Re - Liseve Lodge, 84 North Bersted Street, Bognor Regis. PO22 9AQ - BE/134/20/HH

Planning Officer

Arun District Council, Civic Centre, Maltrovers Rd, Littlehampton, West Sussex, BN17 5LF

CLIENT	Mrs L Parker	DRAWING	002 Proposed Floor Plans		
SITE	84 North Bersted Street, Bognor Regis	DATE	09 09 20	AUTHOR	AH
PROJECT	Extensions & Alterations	SCALE	1: 100 @ A3	STATUS	DRAFT

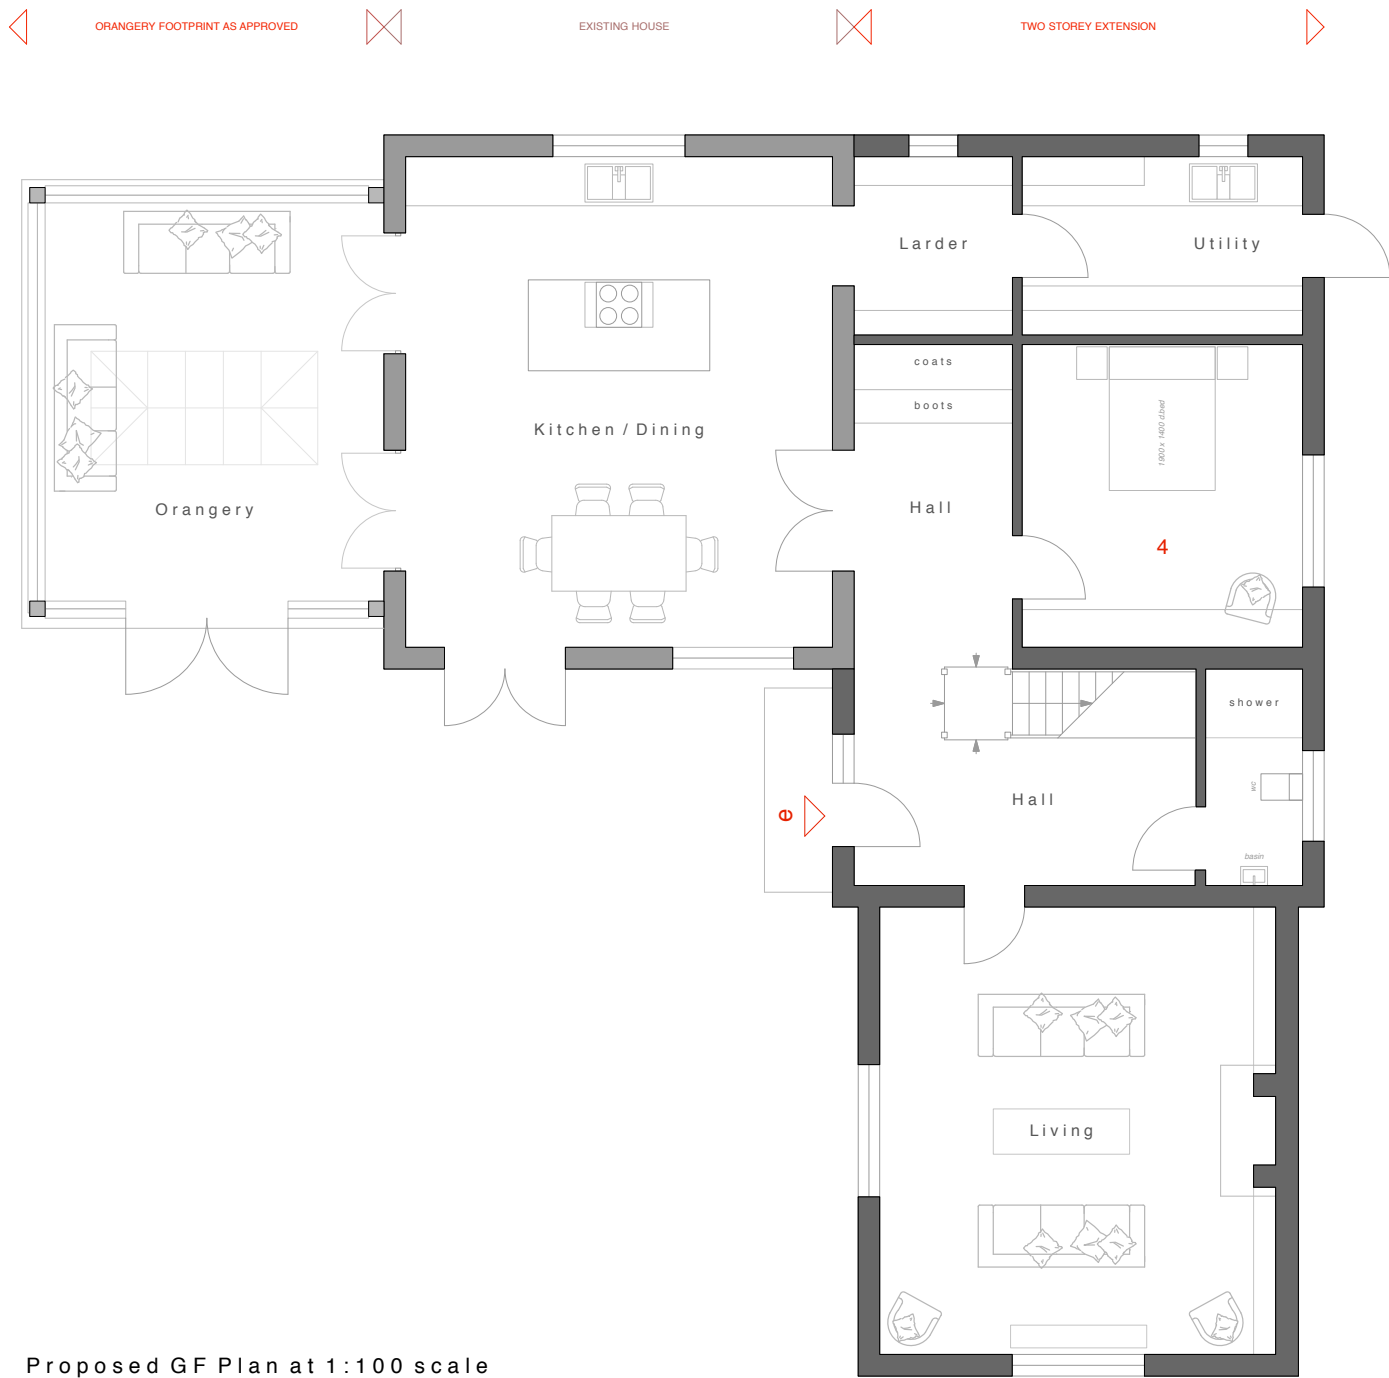
Just following up on our email from Friday, the applicants are happy to reduce the overall scheme and omit FF windows adjacent to no 82. Please let me know your thoughts as to extent and detail and I can provide amended drawings at short notice.

This is due to the size, which is not subservient to the host dwelling and due to its overlooking upon the neighbouring property 82 North Bersted Street.
